Rezoning Transportation Analysis

Petition Number: 2023-080

Date	Description
8-24-23	First Review (JP)
9-20-23	Second Review (JP)
10-26-23	Third Review (JP)
12-20-23	Fourth Review (JP)

GENERAL NOTES FOR PETITION (2023-080)

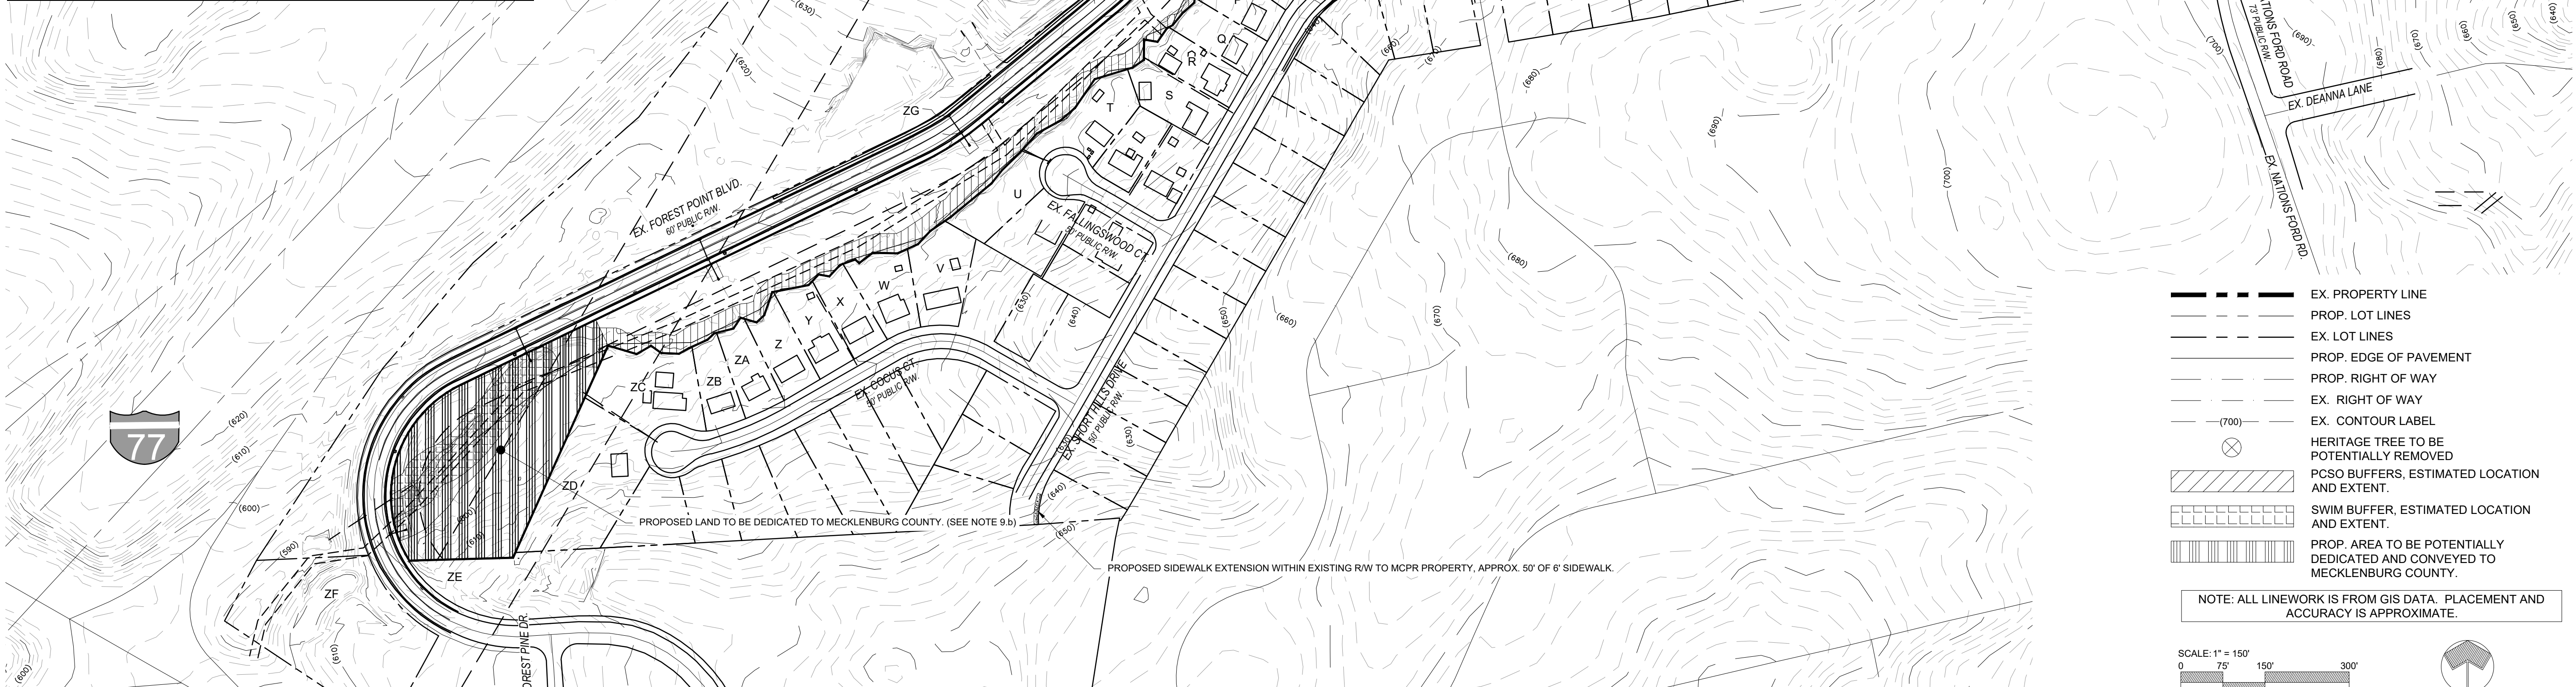
- 5.i. ALL TRANSPORTATION IMPROVEMENTS WILL BE APPROVED AND CONSTRUCTED BEFORE THE ~~THIRTY-FIRST (31)~~ BUILDING CERTIFICATE OF OCCUPANCY IS ISSUED. THE PETITIONER MAY PHASE TRANSPORTATION IMPROVEMENTS IF SAID IMPROVEMENTS AND PHASING ARE EXPLICITLY DESCRIBED IN SITE PLAN NOTES.
9. **New Comment 10.26.23:** 35'x35' sight triangles are no longer in the sight distance policy, this should be 50'x50' sight triangles.
- 5.f. ~~SHALL MEET, PER THE CITY OF CHICAGO'S CURRENT REQUIREMENTS.~~
ADEQUATE SIGHT TRIANGLES MUST BE RESERVED AT THE EXISTING/PROPOSED STREET ENTRANCE(S). TWO 35' X 35' SIGHT TRIANGLES (AND TWO 10' X 70' SIGHT TRIANGLES ON NCDOT-MAINTAINED STREETS) ARE REQUIRED FOR THE ENTRANCE(S) TO MEET REQUIREMENTS. ALL PROPOSED TREES, BERMS, WALLS, FENCES, AND/OR IDENTIFICATION SIGNS SHALL NOT INTERFERE WITH SIGHT DISTANCE AT THE ENTRANCE(S) AND SHALL BE IDENTIFIED ON THE SITE PLAN.

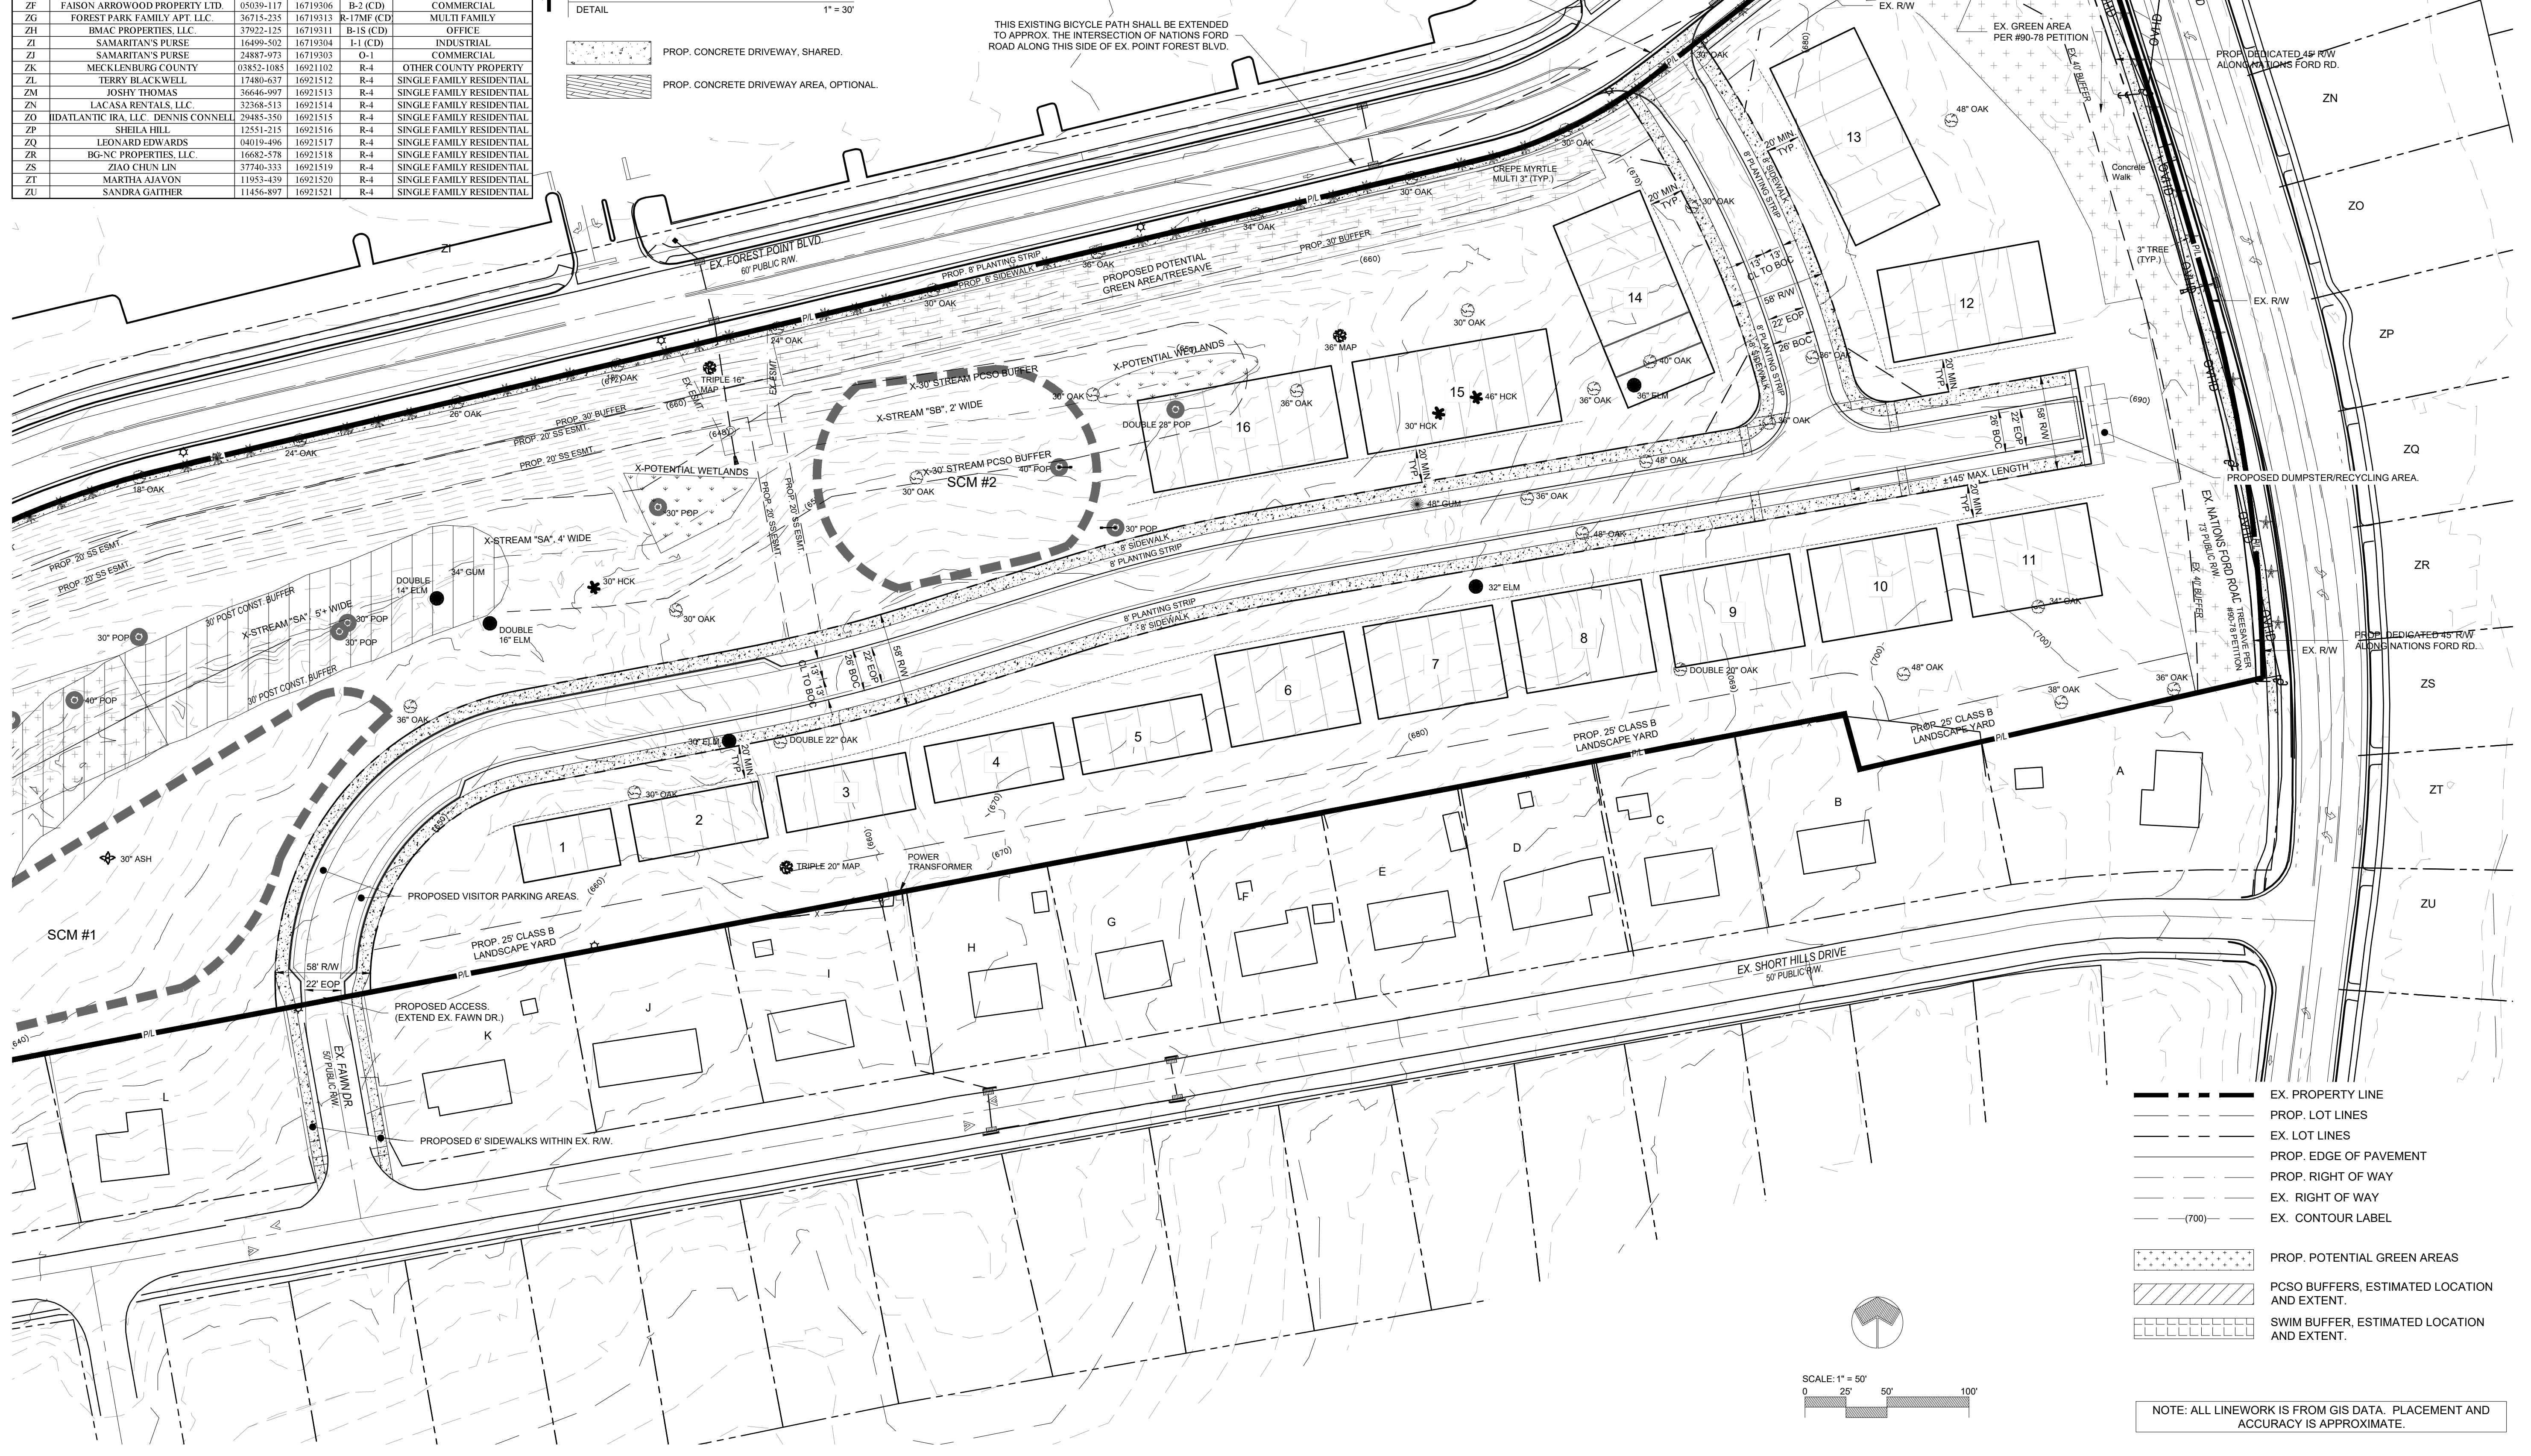
- a. **Forest Point Boulevard:** Future curb line is in the existing location

Clarifying Comment 10.26.23: From the centerline of Forest Point, label and dimension the ROW and back of curb.
